**RE: Administrative Amendment justification letter
Proposed SWMD Maintenance & Administration Buildings Project, COA Project No. 7006.92
4600 Edith Boulevard NE (SE corner of Edith and Comanche)
ZONE ATLAS PAGE: G-15-Z
DRB Case SI-2019-00032**

- Development Review Application
- Form P3
- Official Notice of Decision
- Original approved Site Plan
- Original approved wall elevations
- Revised Site Plan with the above changes clouded
- Revised wall elevations
- Zone Atlas map with site outlined and labeled

DECEMBER 10, 2019
SHEET No. SP-1

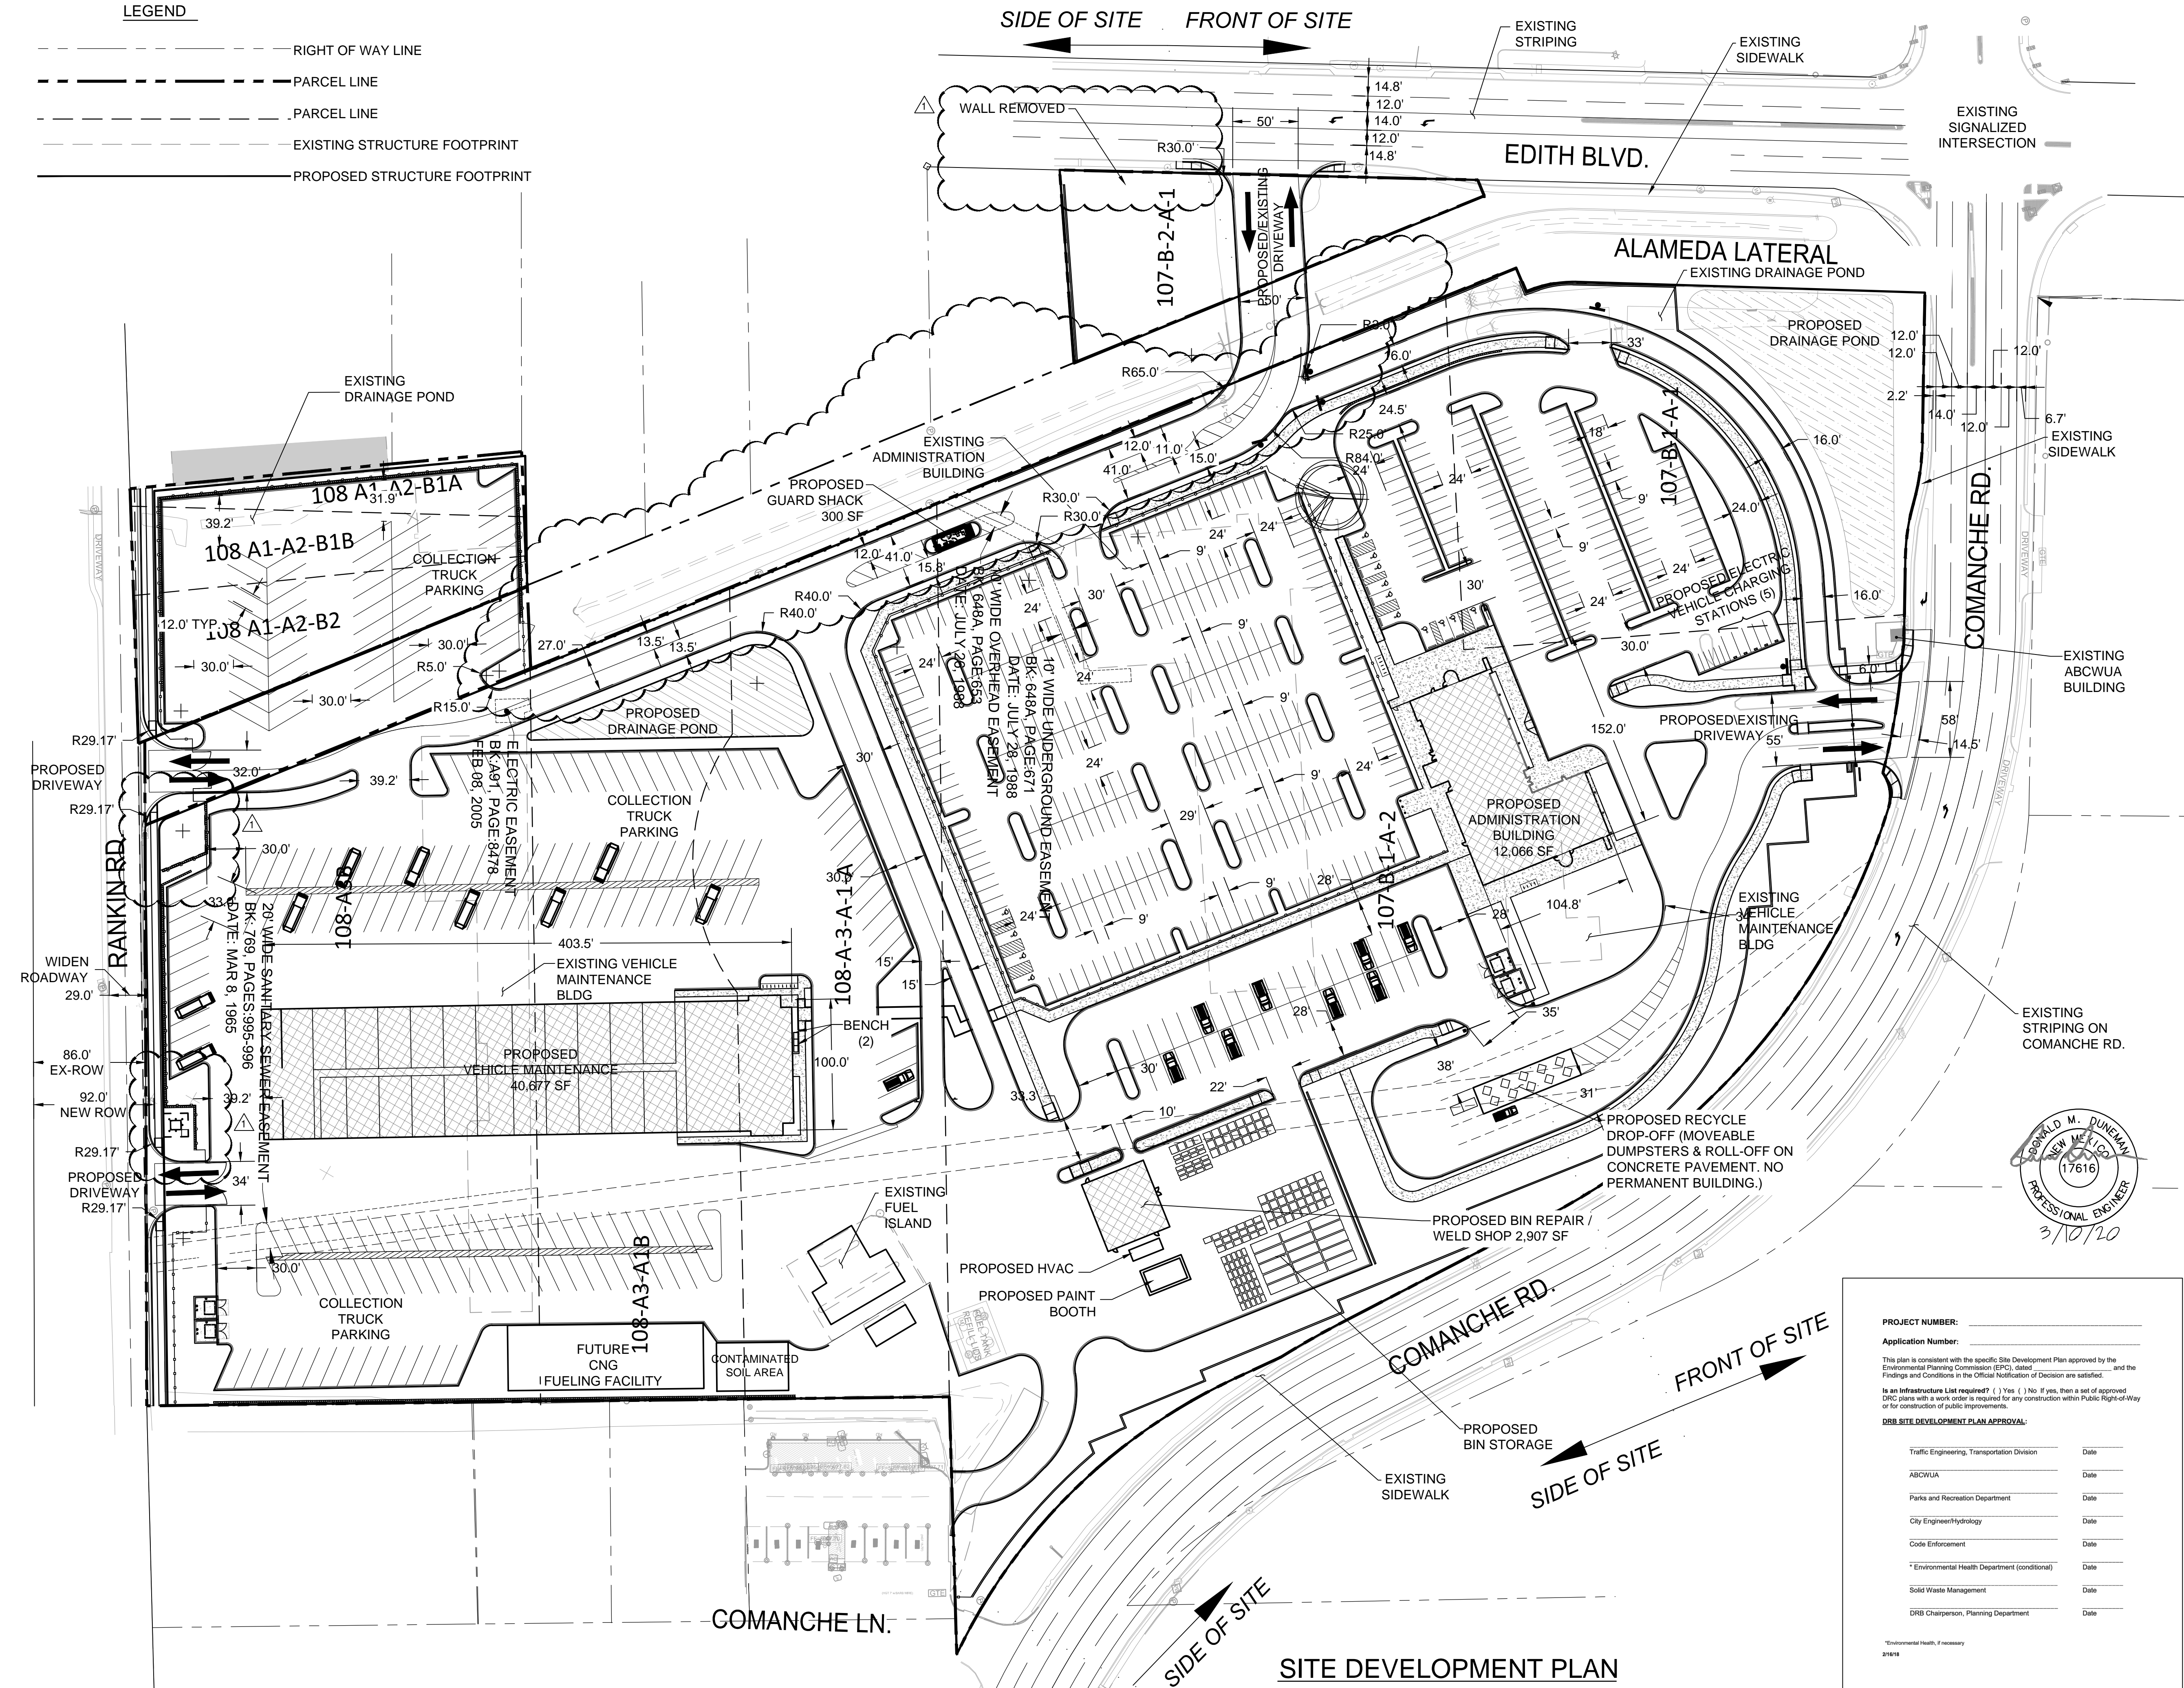
- b. Layout change. At the request of PNM the wall alignment along with the on-site curb has been adjusted at the east entrance to accommodate the installation of the PNM transformer to be at the grade of Rankin Rd. At the request of the ABCWUA the alignment and on-site curb has been adjusted at the western entrance to accommodate the site water meter to be at the grade of Rankin Rd. In both cases the wall has been realigned into the site along with the curb. The height of the wall has not been adjusted from the approved plan.

- 2. Screen wall 07 layout adjustment**
 - a. At the entrance off Edith the approved plan had this wall located within the MRGCD Alameda Lateral ROW. The wall has been adjusted to run parallel to this ROW now.

- 3. North/South internal access road.**
 - a. The width of this road has been reduced by 3' from 30' to 27' and 44' to 41' to resolve an issue with curb and site lighting.

- a. With the change to the internal access road, the short retaining wall was no longer needed. The chain link fence will remain. The maximum height of this wall was 2 feet.

- a. The 3' tall screen wall that was approved running parallel to Edith has been removed. The area behind the wall has been full landscaped during the current construction.
